An
Bord
Pleanála

Inspector's Report ABP-306725-20.

River Poddle Flood Alleviation Scheme.

South Dublin County Council and Dublin City Council.

Figure 4-3: Option 2 Whitehall Park with terracing

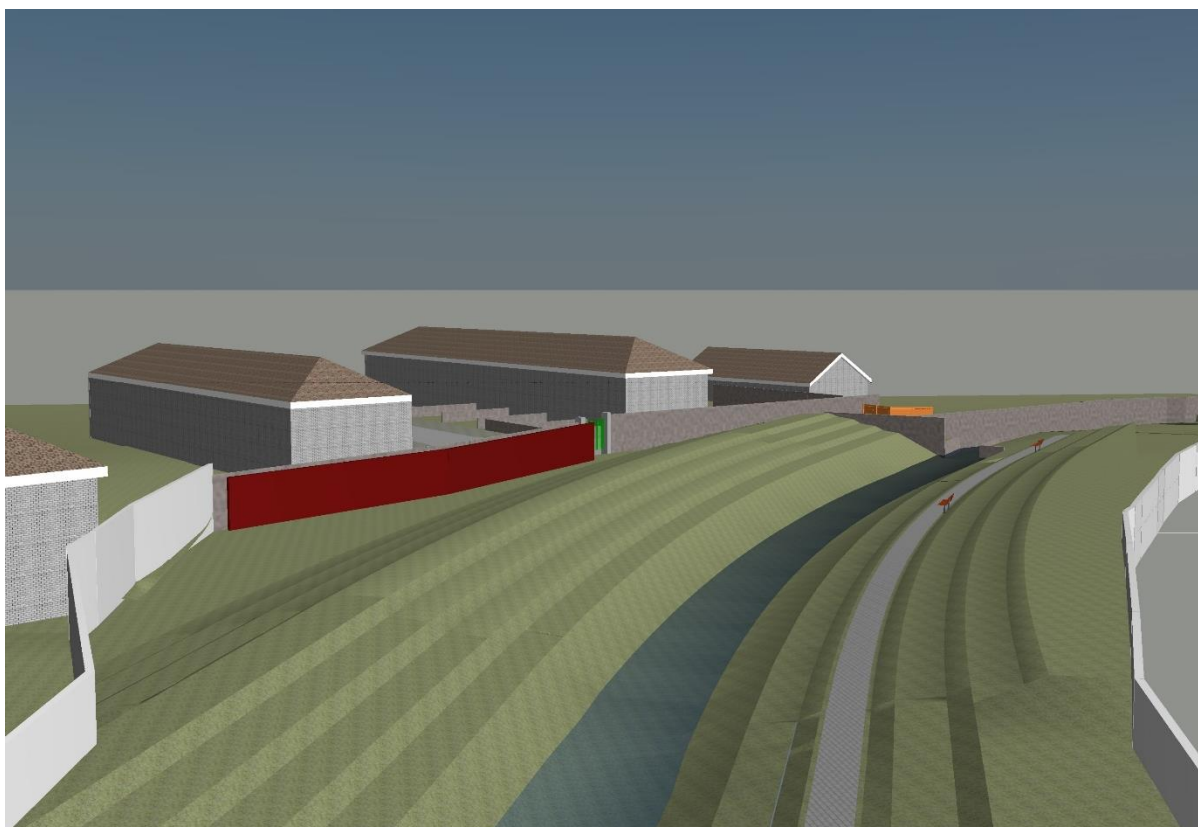
Mitigation measures regarding the realignment of the river at Whitehall are inadequately described. Diversion of the river is of concern.

Figure 4-4: Option 1 flood protection proposals for Ravensdale Park

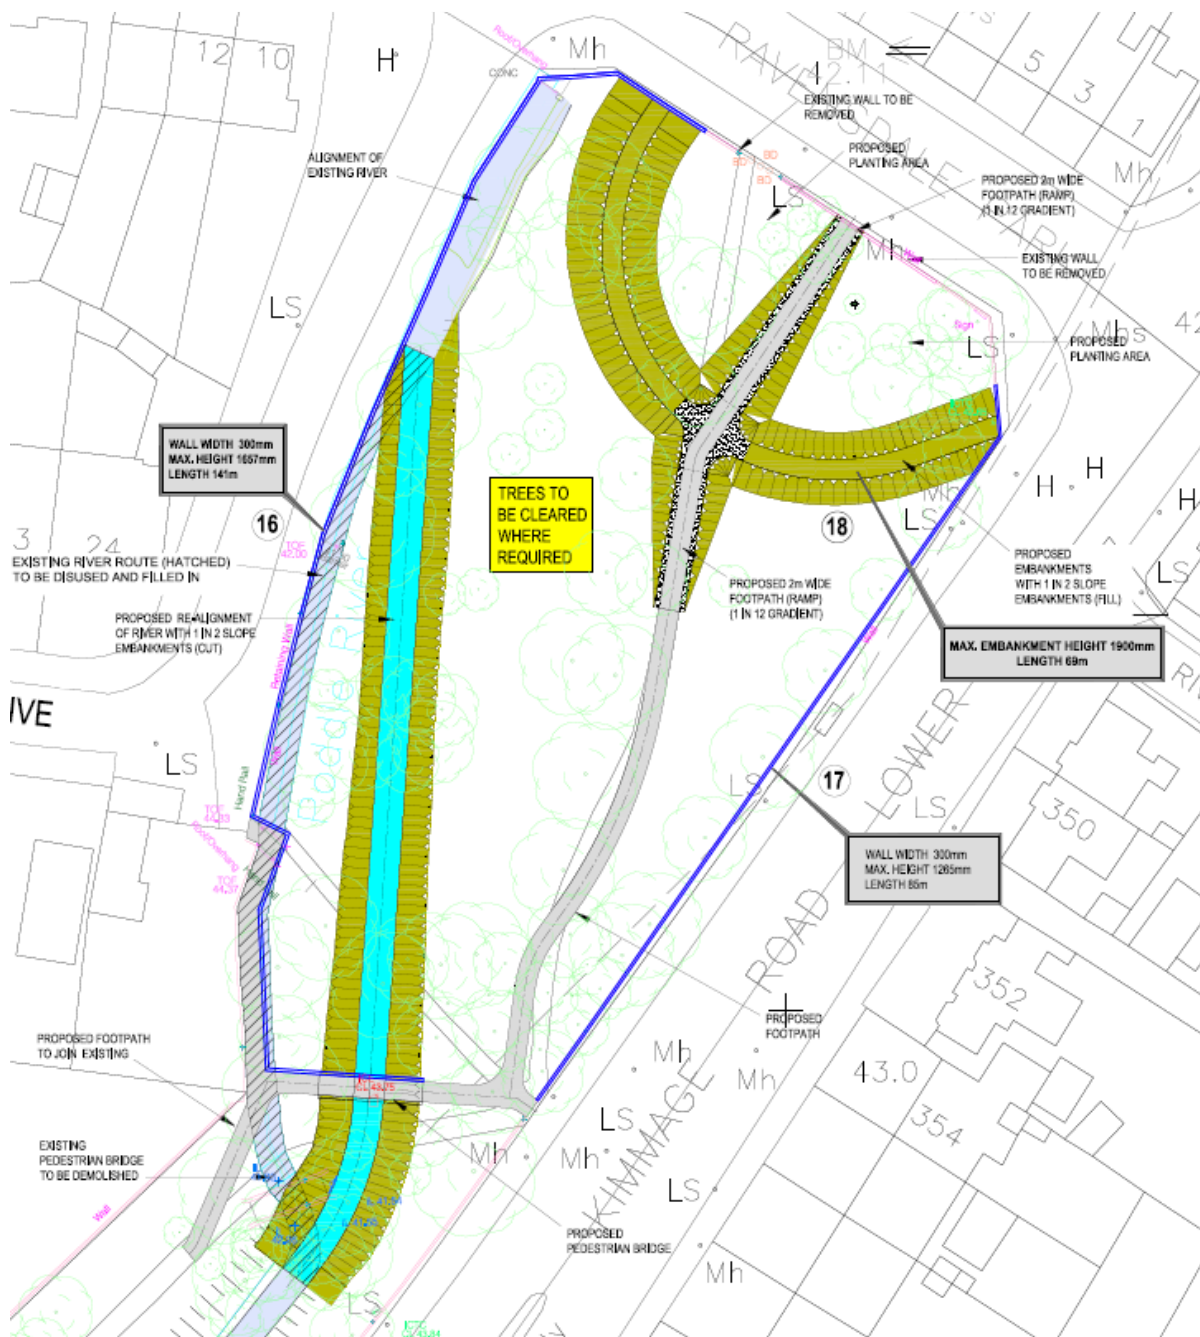
Ravensdale Park is heavily used. The centrally placed concrete retaining wall will be visually imposing and reduce the amount of contiguous usable space and bisect the park. The design is inappropriate given the very limited green space in the area.

The park in its entirety should be considered as the flood zone and allowed to flood every 5 to 10 years.
